From:
Sent: 05 September 2026 14:40
To: DC Admin
Subject: Objection to Planning Application 2026/62/91926/E - 158 Hawthorne Way Shelley

Planning has recently been granted for 156 Hawthorne Way (ref. 2025/93035, dated 10/03/2026, Responding Officer D. Stainsby, Ref K12-41/4), for a garage extension and conversion to part living space. However, the use of the service strip as parking in this plan was refused.

Proposed Site Layout
Scale 1:250

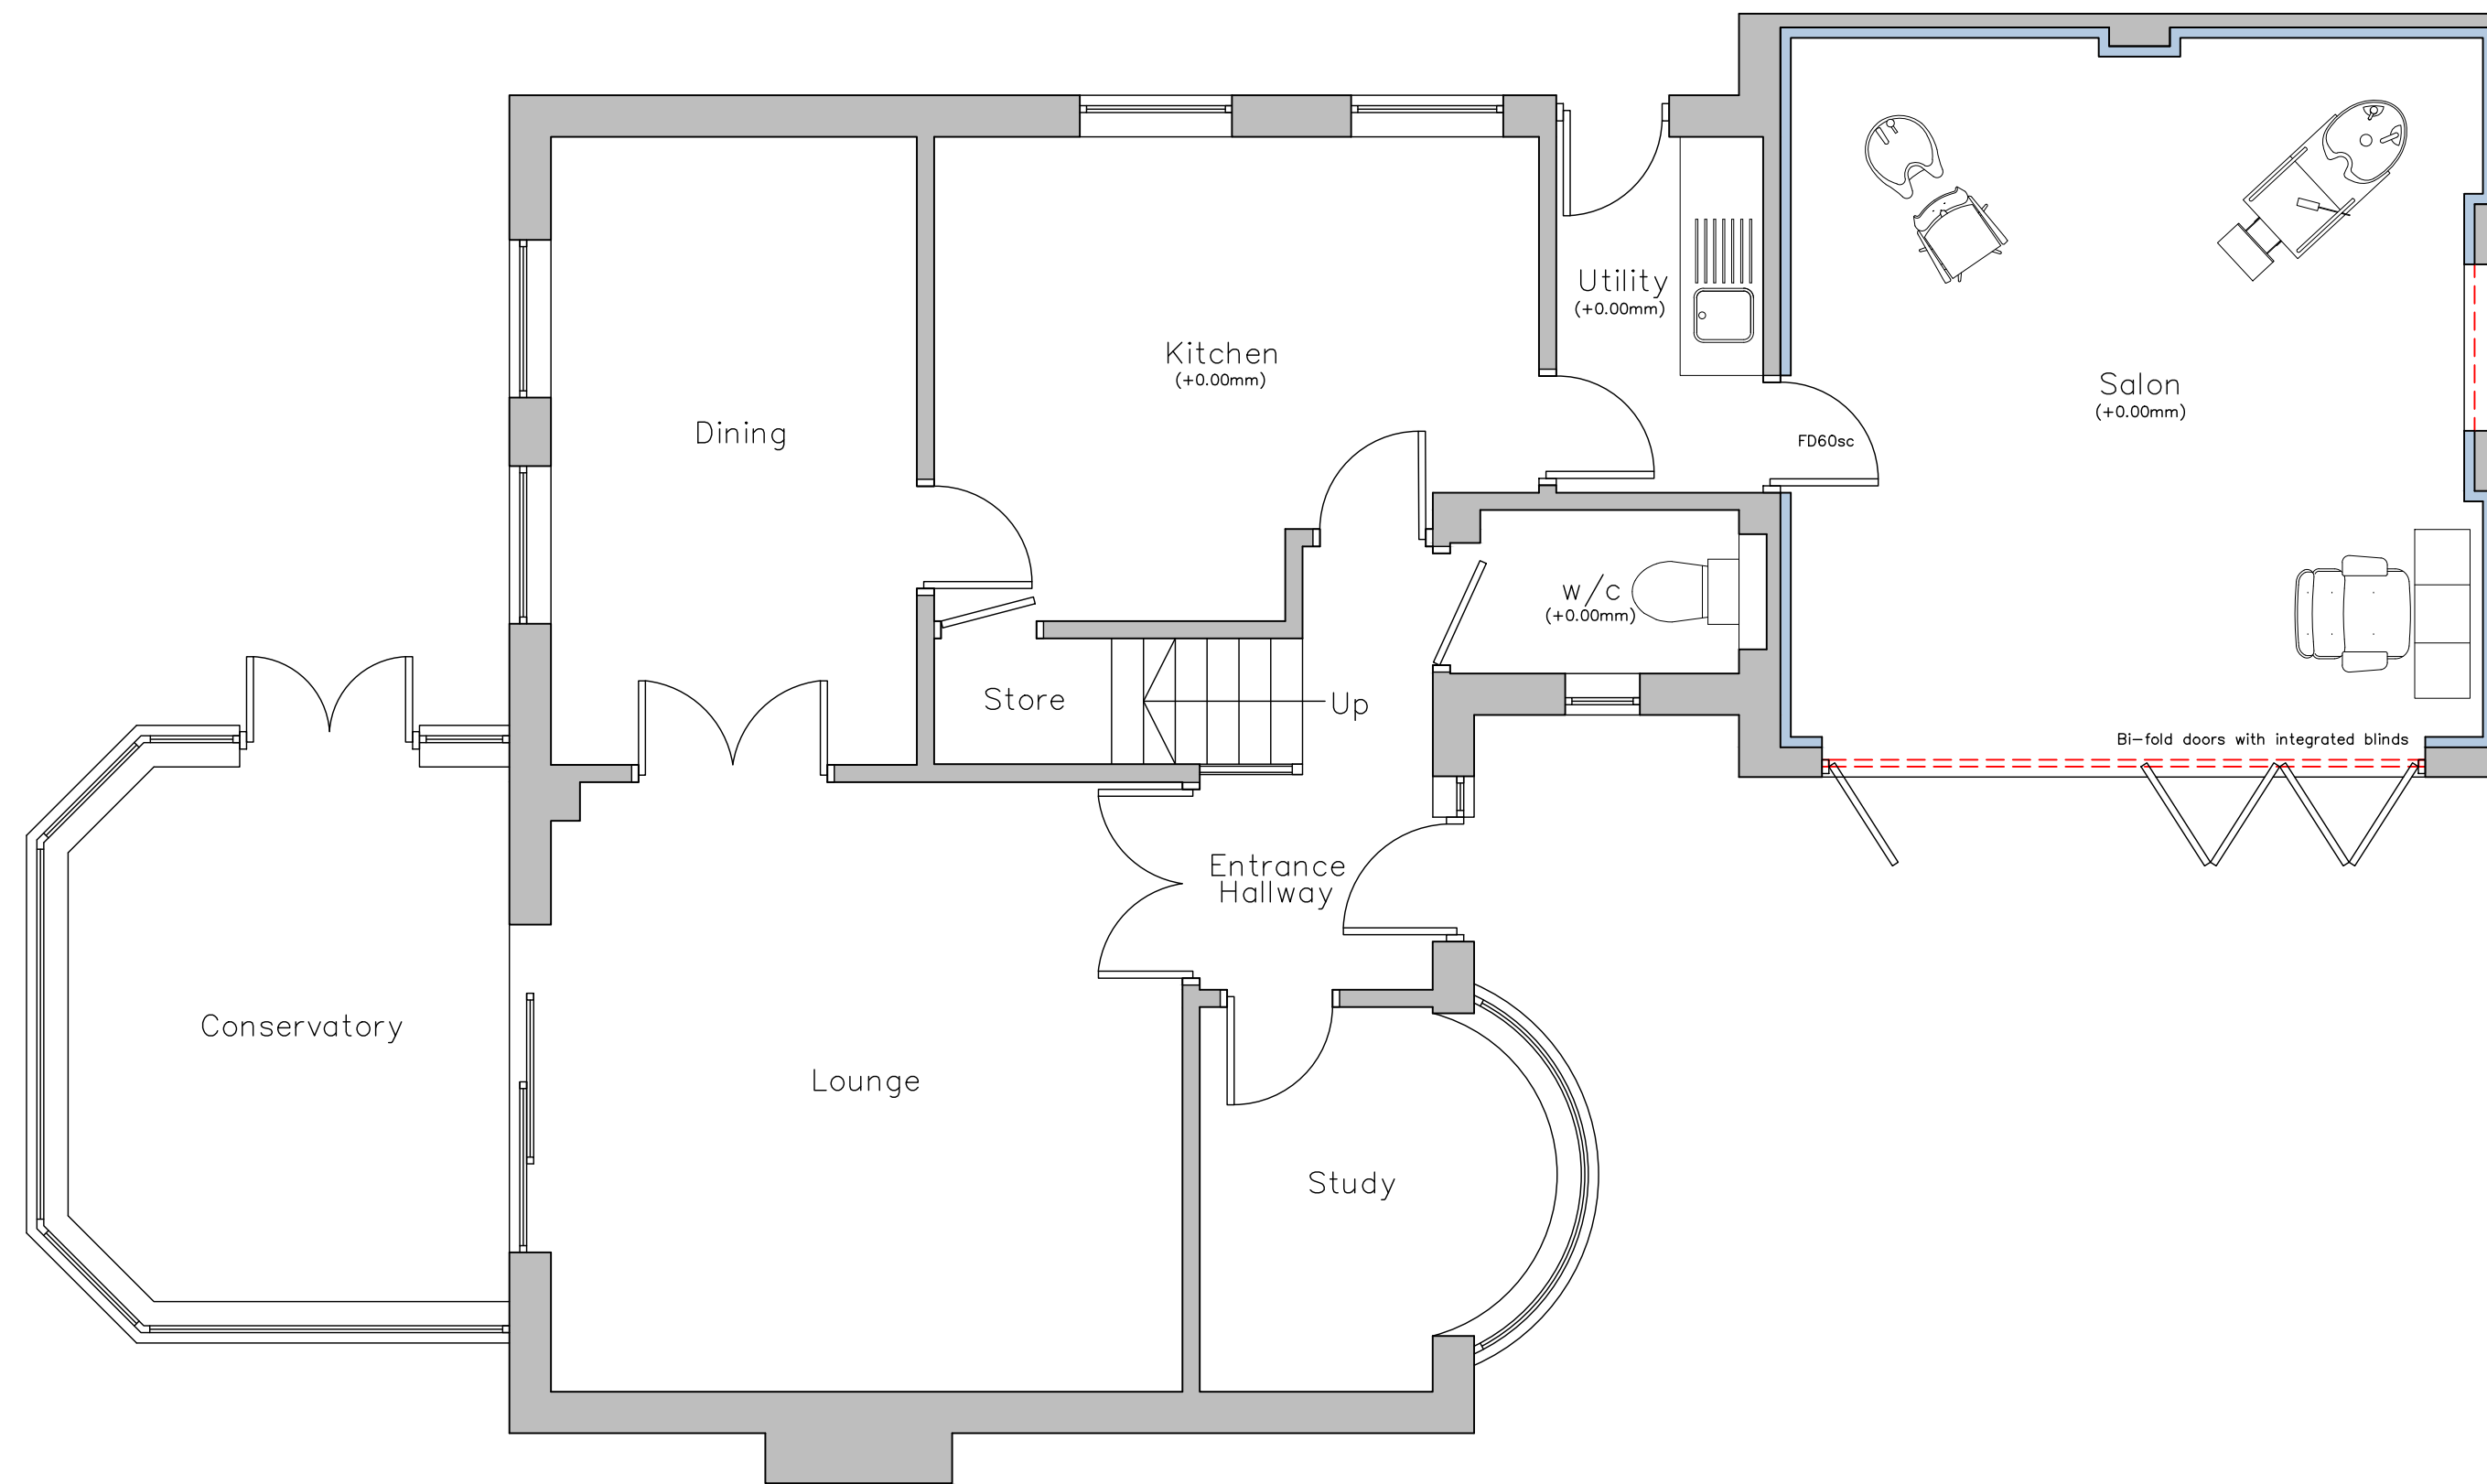
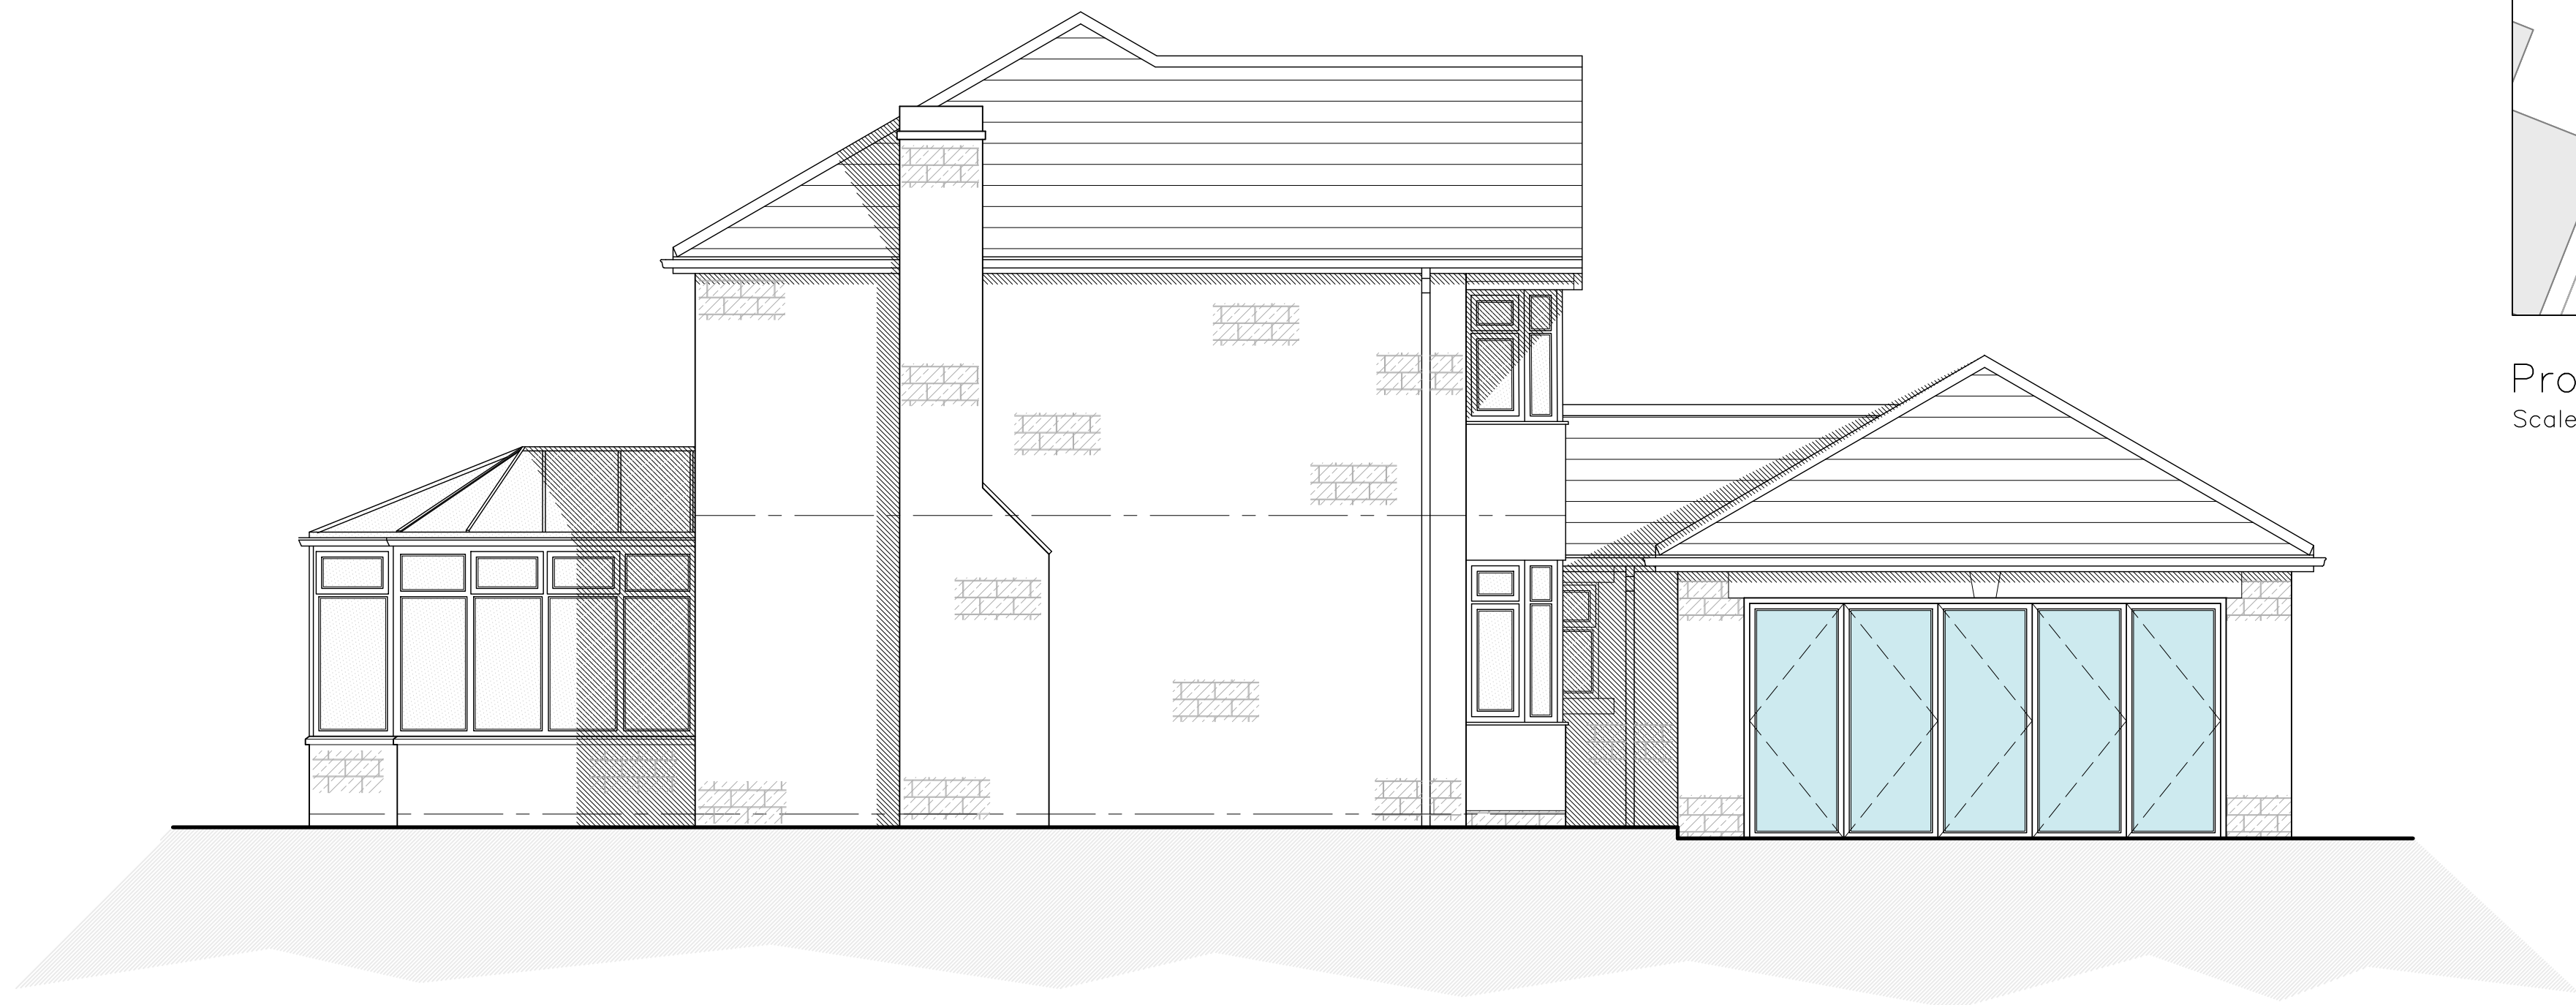
I am writing with further information concerning my objection to the above planning application.
I wish to submit supplementary evidence in support of the points I raised regarding parking provision and the highway-service strip ownership

As a result, there is not sufficient width to provide a parking space as proposed within the curtilage of the property at this location and Highways D.M cannot support the application as submitted

I feel this is also applicable to the proposed plans for 158 Hawthorne Way and that Highways should be consulted as to the status, use and ownership of said 1.8 metre service strip.
